KITTITAS COUNTY COMMUNITY DEVELOPMENT SERVICES

**RE: JB Development Short Plat, File Number SP-07-78
Revised Conditional Preliminary Approval**

JB Development Short Plat (SP-07-78)

DWN BY G. WEISER	DATE 03/08	JOB NO. 06209
CHKD BY D. NELSON	SCALE 1"=100'	SHEET 1 OF 3

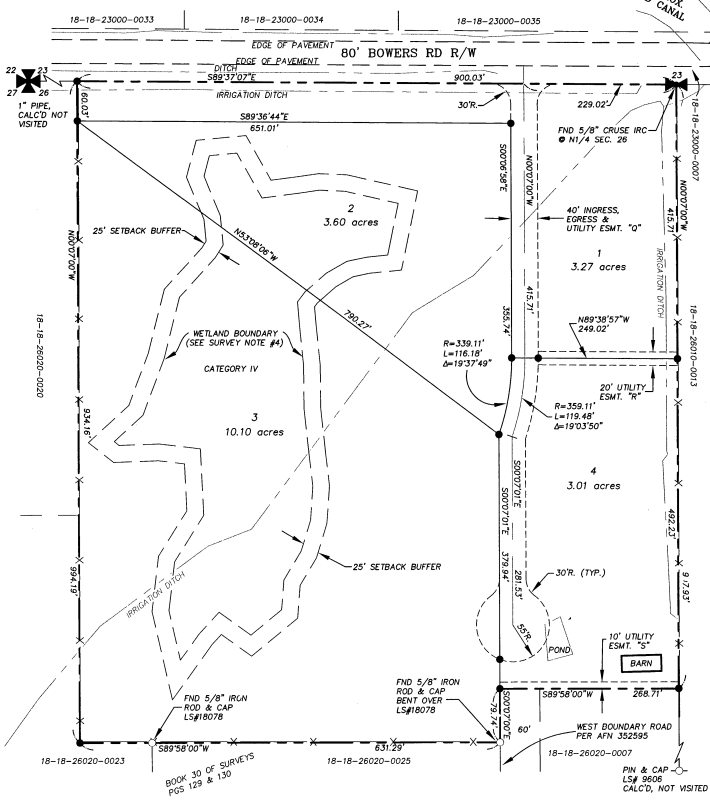
- 1) Both sheets shall reflect Short Plat Number SP-07-78.
- 2) The vicinity map shall clearly identify and depict Water Street in relation to the subject parcel.

- Future development shall occur in compliance with KCC 17.58: Airport Zone.
- 4) The location of Bowers Air Field in relation to the subject parcel shall be clearly depicted in the vicinity map on sheet one of the JB Development final mylars.
